**EL PASO COUNTY PLANNING AND
 COMMUNITY DEVELOPMENT
 DEPARTMENT**

GRADING AND EROSION CONTROL PLAN CHECKLIST

JOB NUMBER: 65120399  
DATE: 02/07/2020  
SHEET: GEC-2  
3 of 4

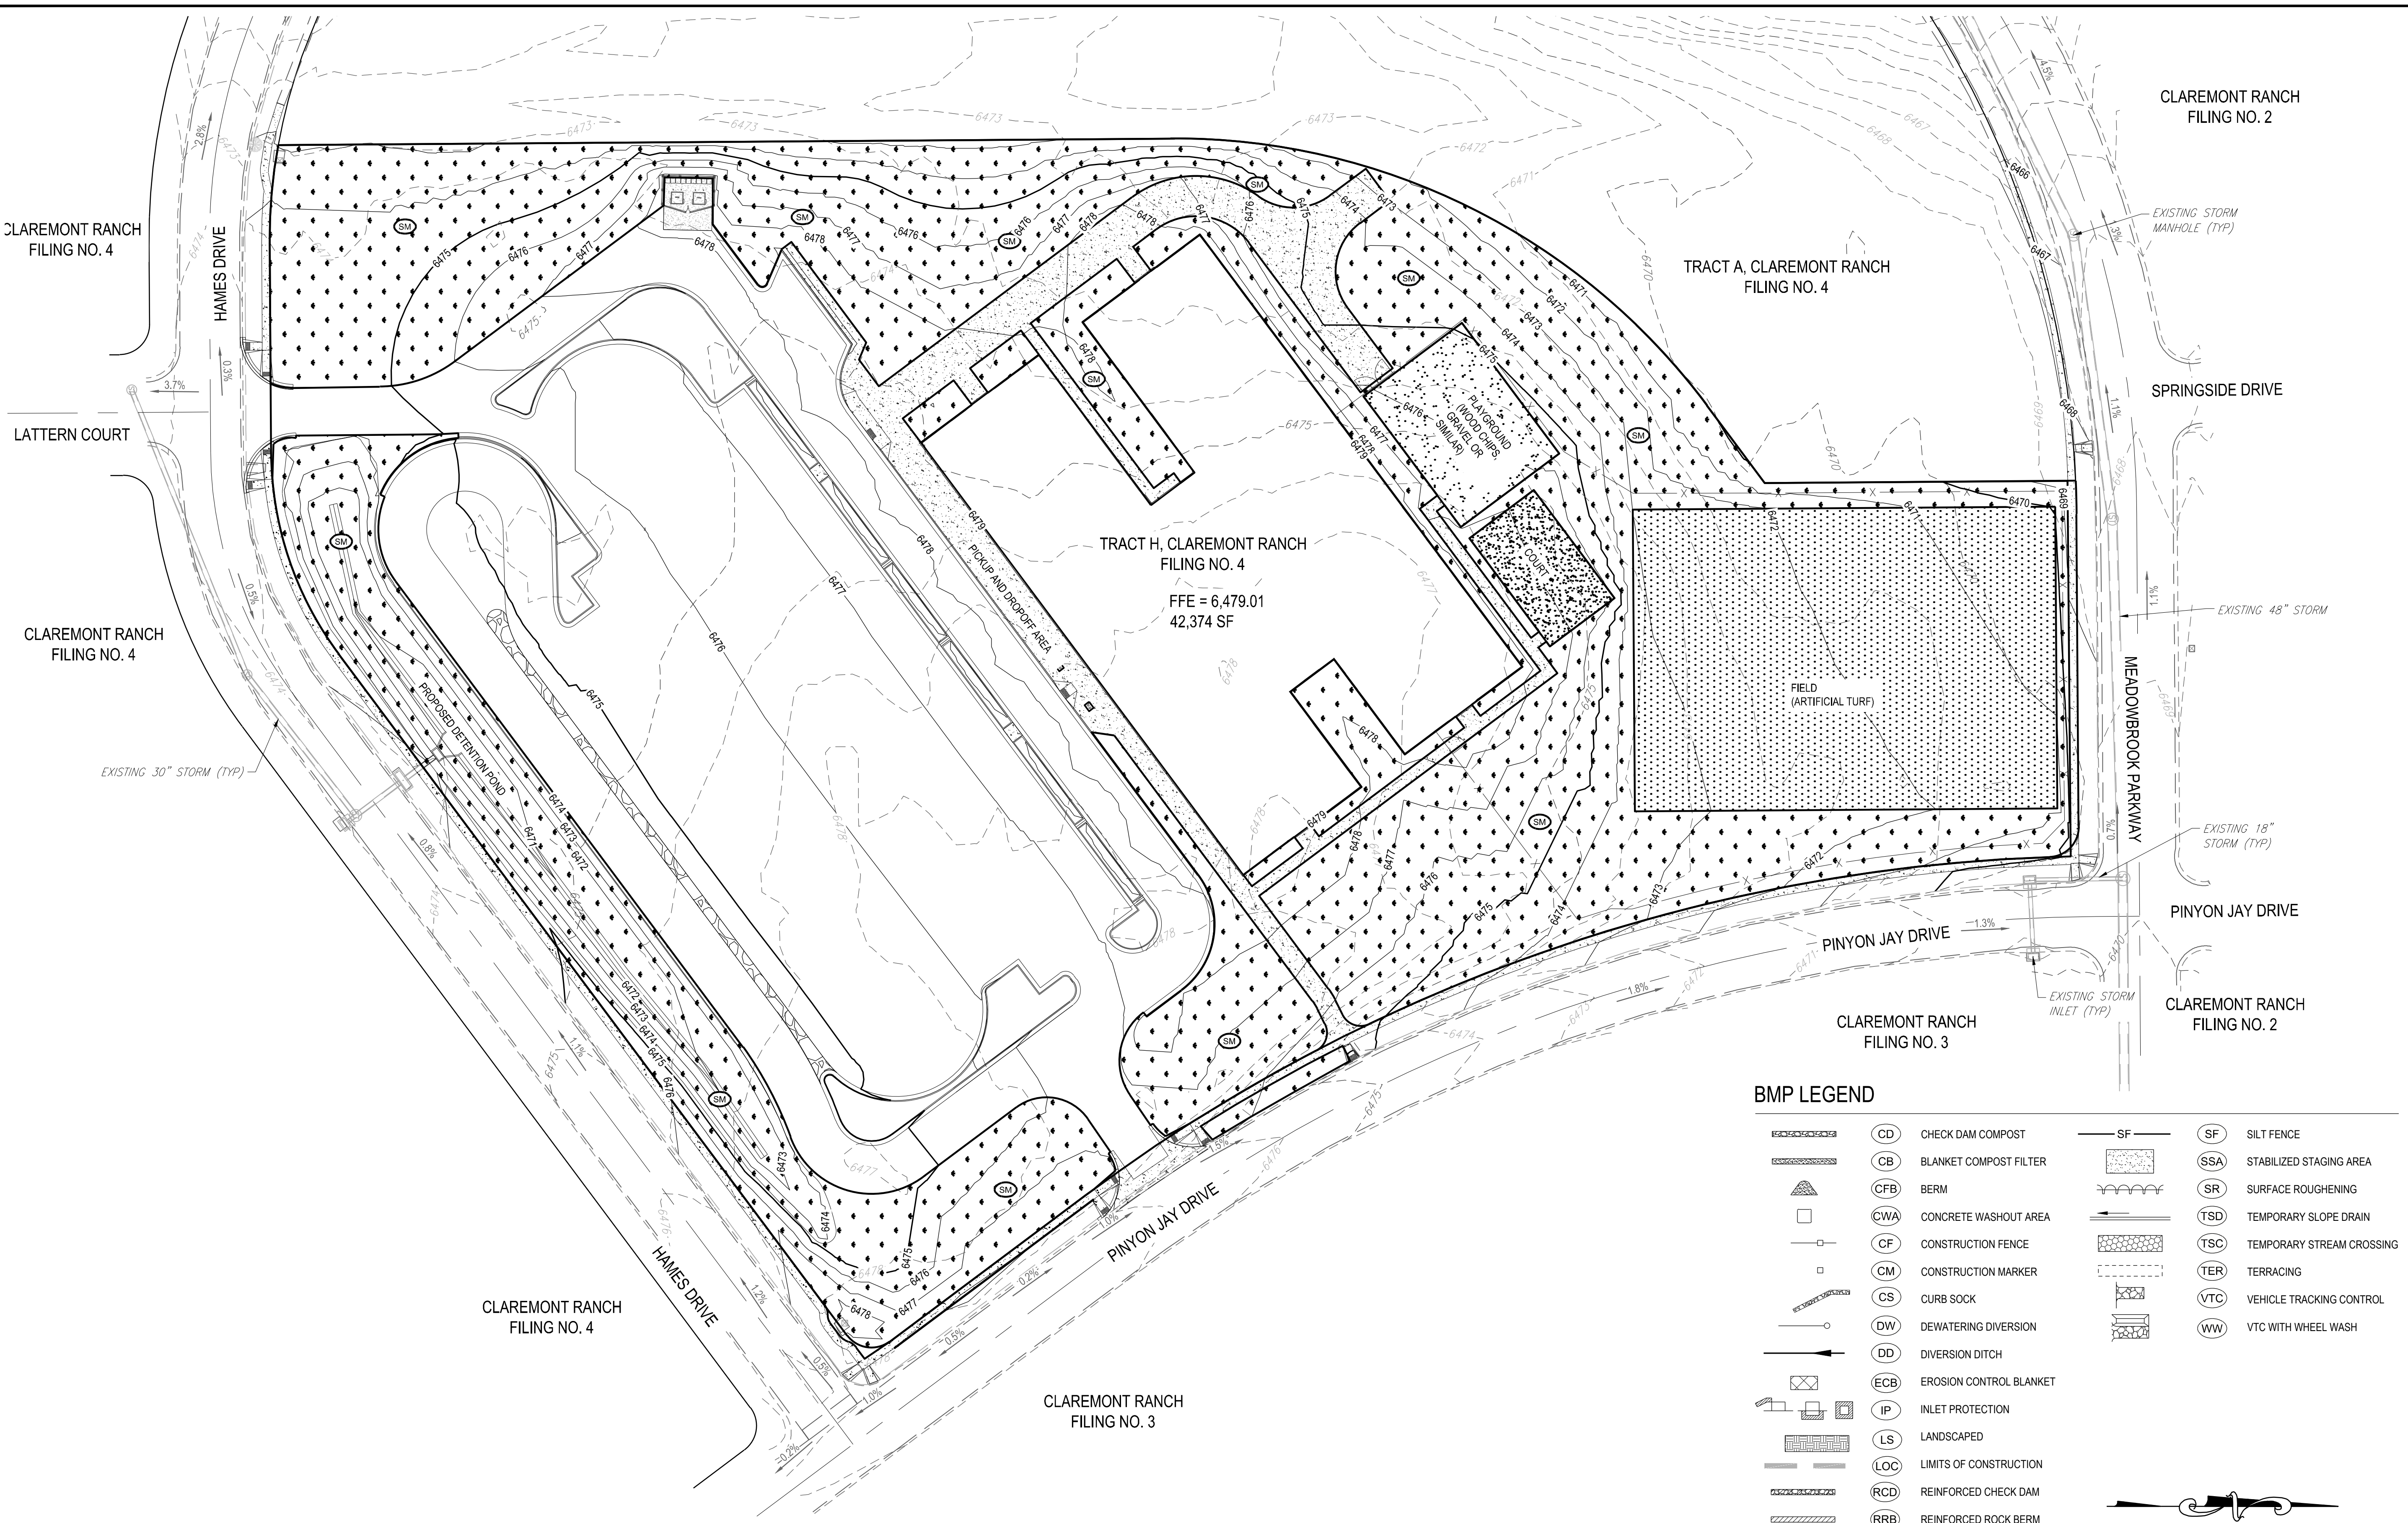
All proposed temporary construction control measure details. Custom or other jurisdiction's details used

must meet or exceed EPC standards.

Limits of disturbance delineating all anticipated areas of soil disturbance

Legend for all symbols used in the plan.
